From: [SBMTNA](#)
To: [Rodenbeck, Jay B.](#)
Cc: [salamdezia@gmail.com](#); [jeslopez102@gmail.com](#); [gilbert.speakman](#); [Rosalie Martinez](#); [dznaranjo30@gmail.com](#); [meliszdelia@gmail.com](#); [illgen](#); [NaranjoLopez2010@gmail.com](#); [Hess Yntema](#); [Baca, Joaquin](#)
Subject: PR-2024-009765 / SI-2024-00468 - 1100 Woodward NE
Date: Wednesday, April 9, 2025 2:35:25 PM
Attachments: [martineztown_24X36_IDOZoning_2020.pdf](#)
[1100 Woodward NE - 8.5x11 - Scale in Feet.pdf](#)

Santa Barbara Martineztown Neighborhood Association (SBMTNA) appreciates that you informed the neighborhood association of the subject case for your review. SBMTNA was not able to attend the meeting due to late notice of the meeting. SBMTNA disagrees with any approval of the site plan at this time.

Loretta Naranjo Lopez, President
SBMTNA

NOBIS REHAB HOSPITAL 1100 WOODWARD PL.	DRAWN BY pm
	GRADING PLAN	DATE 7-14-25
		SHEET # GR-1
		JOB # 2023123

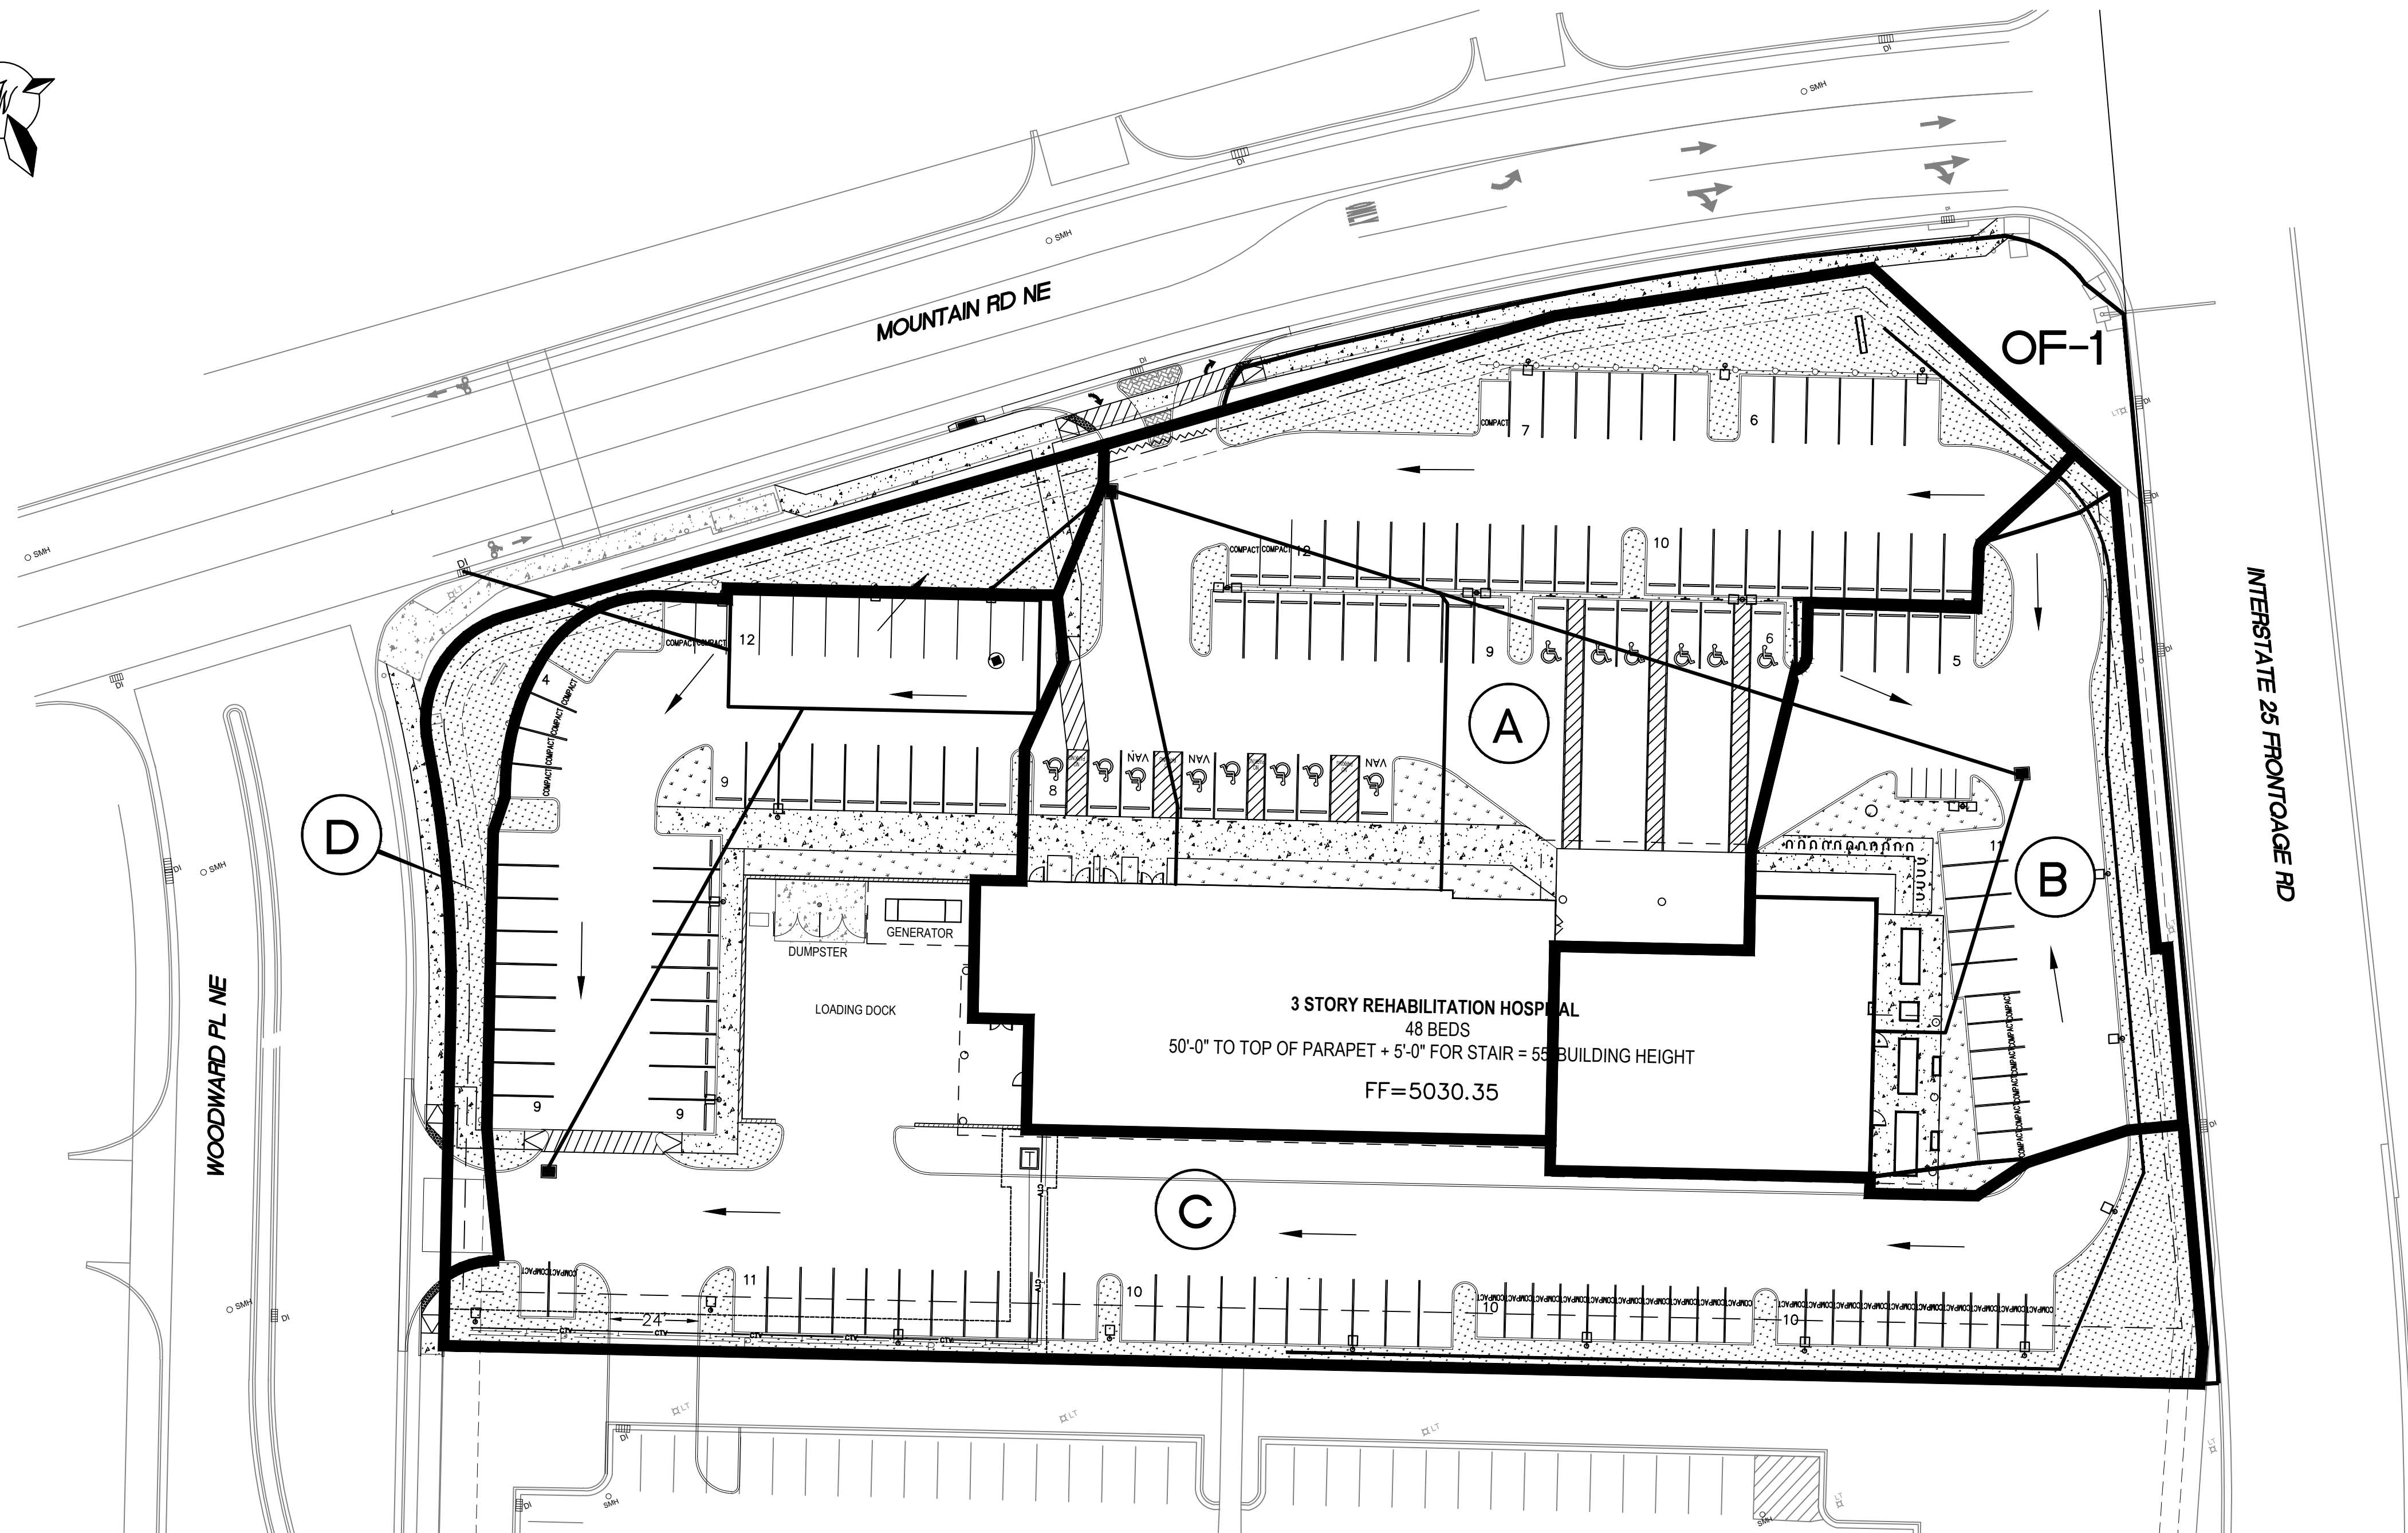
In regards to drainage from the Gateway site, the current ponding is not sufficient. The debris during a harsh rain will flow over into the residential properties down below and causes flooding, and extensive mud and debris flow down Mountain Road NE and each of the residential streets on the west end of the Gateway property. This area needs to be studied extensively in order to protect the residents surrounding the Gateway property.

1100 Woodward NE

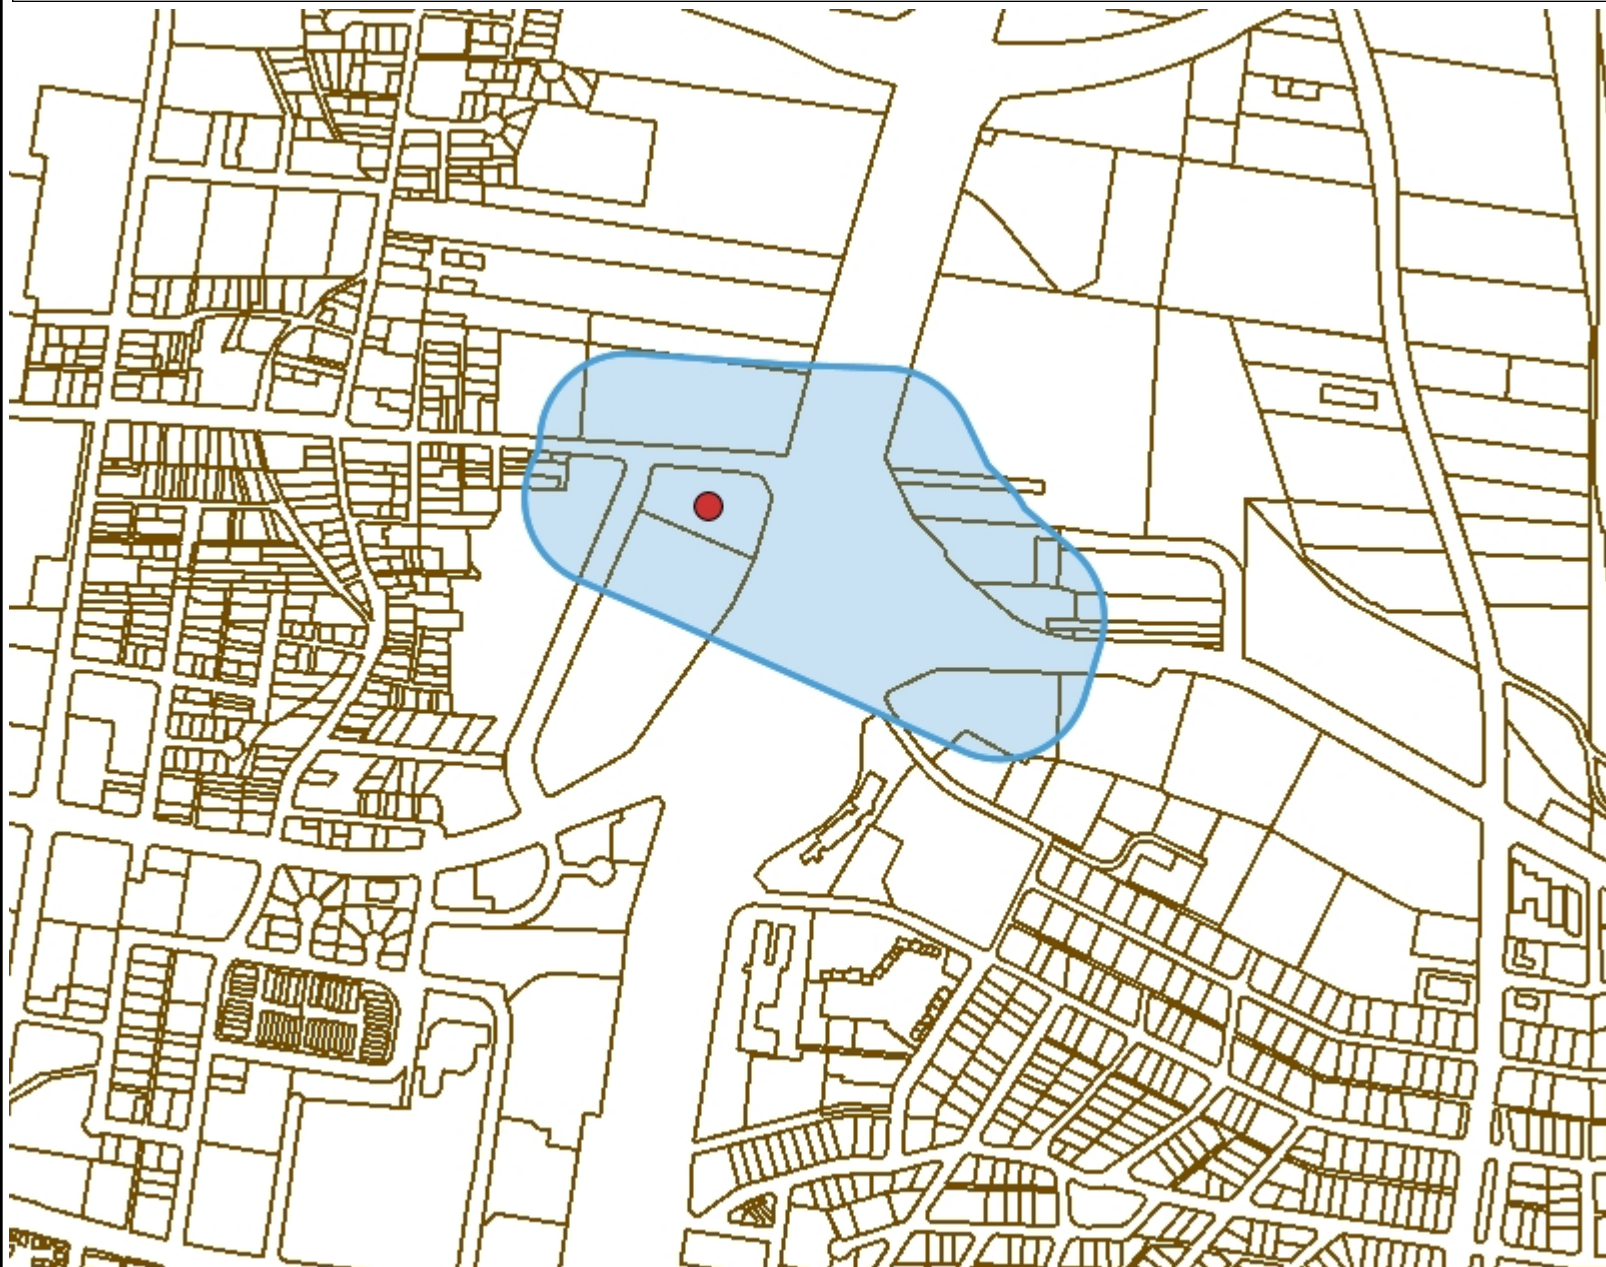
The requirement for 330 feet was evaluated by the Planning Department. I provided the buffer map for

your records. The buffer map shows the R-T property is within 330 feet. The attached Martineztown zone map of 2020 shows the rectangular piece of property as the R-T zone in yellow. In the buffer map it is labeled with the number 6 and it has a file number SP-82-147, but does not have the new zone map showing the residential zone. The land use is residential surrounding the westside of the Gateway property.
